Our ref: HA/2022/123851/01-L01
Your ref: LU/369/21/RES
Date: 24 January 2022

**APPROVAL OF RESERVED MATTERS FOLLOWING OUTLINE CONSENT
LU/47/11/ (AMENDED UNDER LU/182/15/PL) FOR THE FORMATION OF THE
CENTRAL WETLAND AREA AND THE CONSTRUCTION OF THE CENTRAL SPINE
ROAD RUNNING ACROSS THE CENTRAL WETLAND AREA, LINKING UP PHASE
5 AND PHASE 2B (ALSO KNOWN AS PHASE 4). CENTRAL WETLAND AREA
HAMPTON PARK TODDINGTON LANE LITTLEHAMPTON BN17 7PL**

Environment Agency Position

ELEVATION SINGLE SPAN

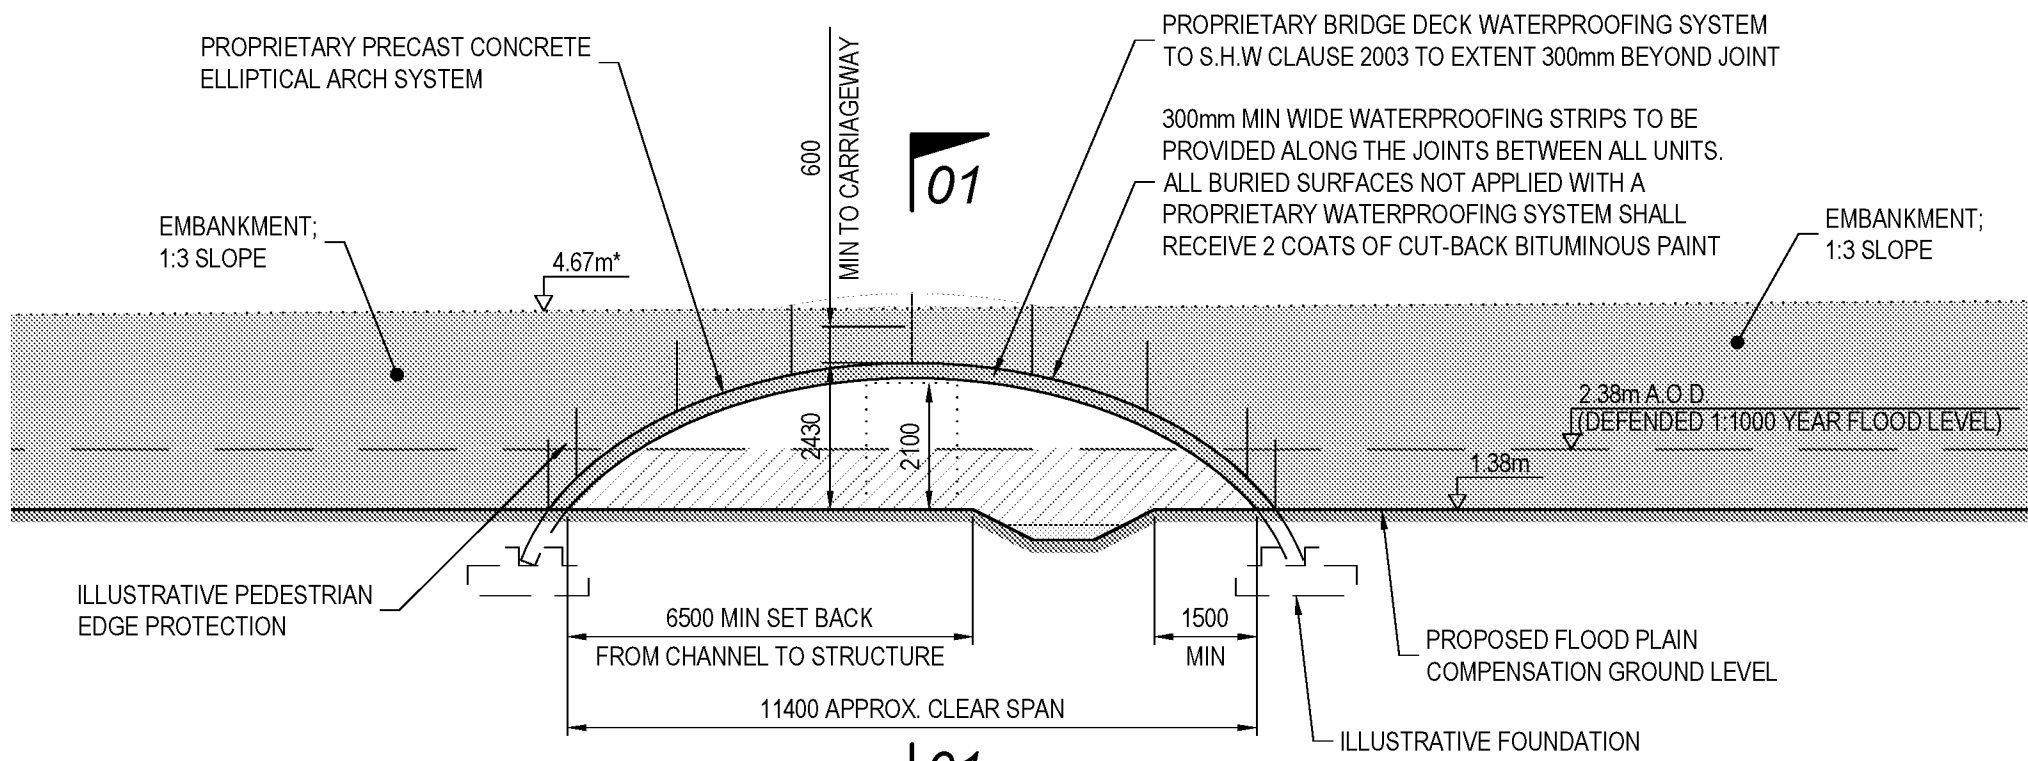
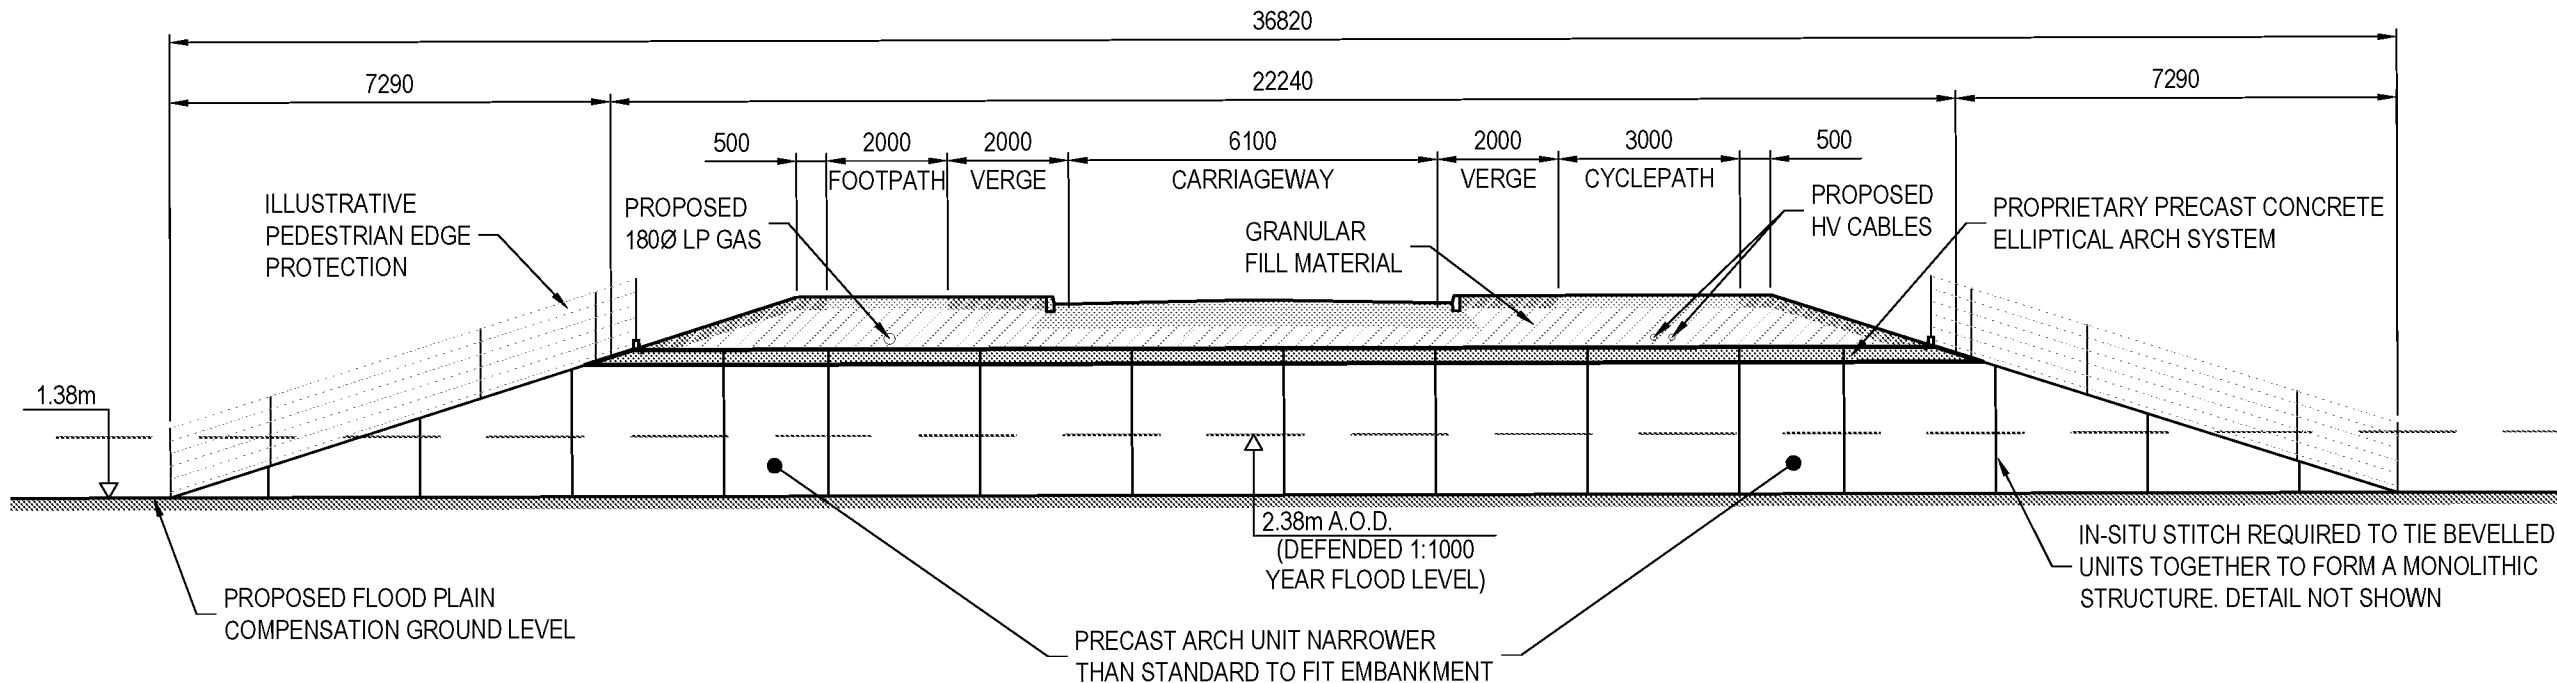
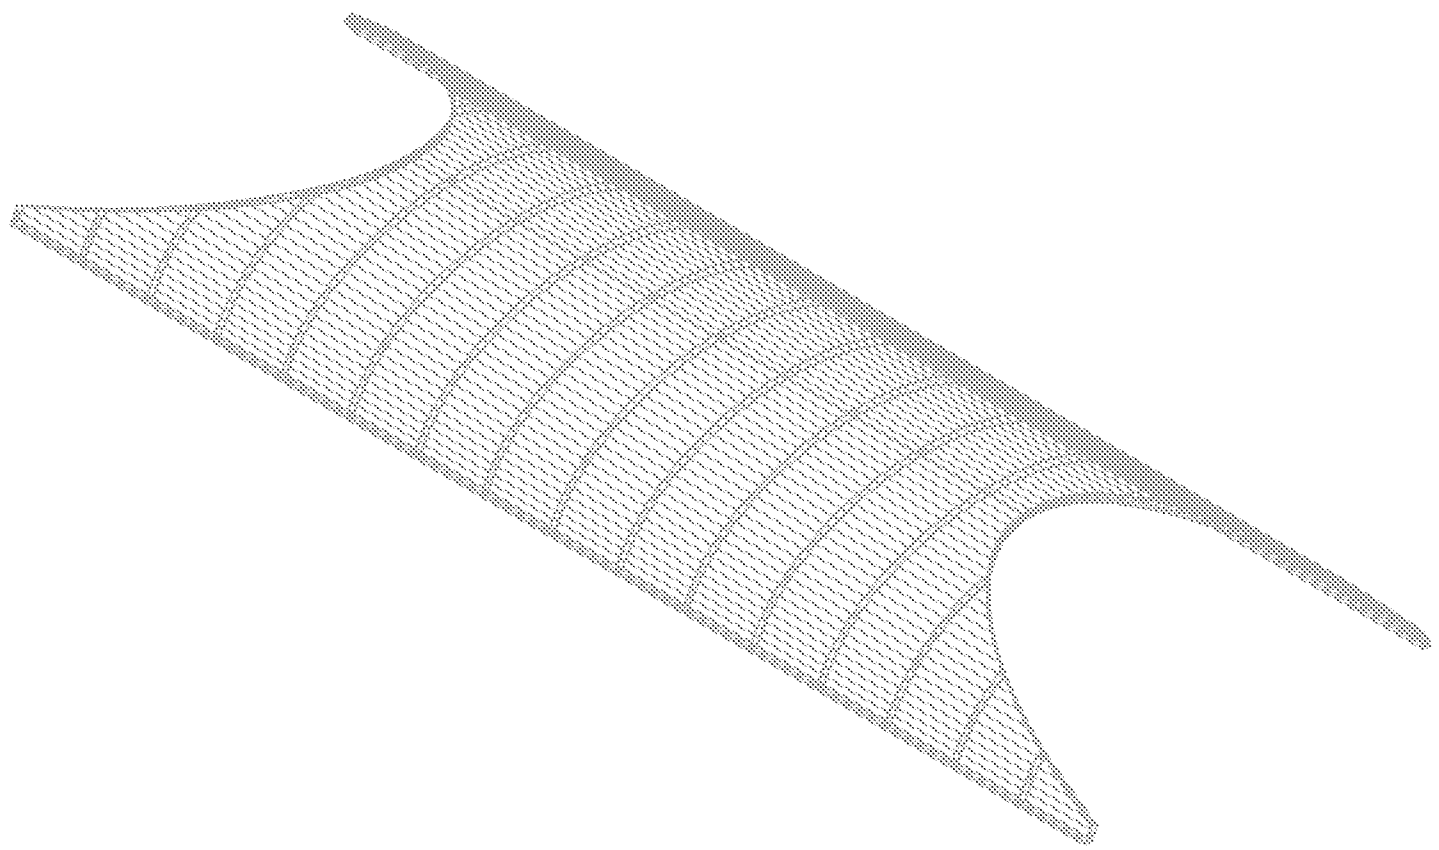
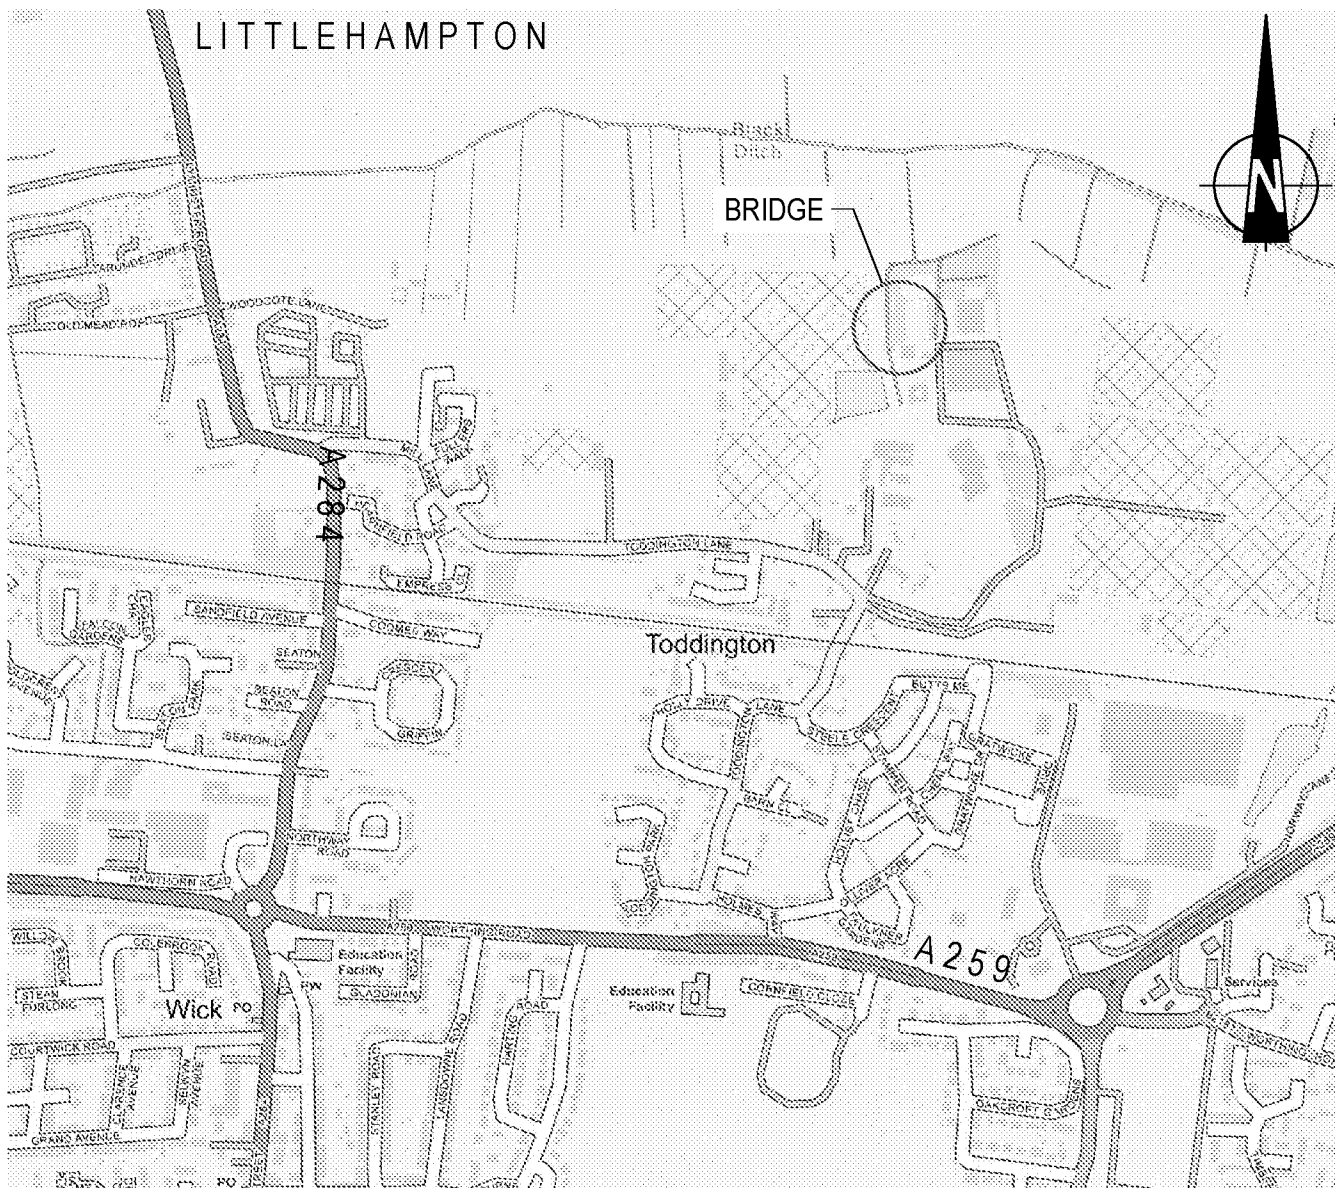
- Unsatisfactory information in regard to the watercourse crossings have been submitted.

In our previous responses we stated that the EA will always request road crossings to be of a clear span variety, for the purposes of flood flow. Also, the soffit level should be set at least 600mm above the undefended 1% AEP plus the appropriate allowance for climate change. In this case it appears that defended levels have been considered. Furthermore, culvers have been proposed as a means of crossing for the footpaths which are against EA policy. It'll also be useful if evidence of discussions about the arch crossing can be provided to confirm this was agreed as an appropriate means of crossing.

To overcome our objection, the applicant should submit a revised FRA which addresses the points highlighted above.
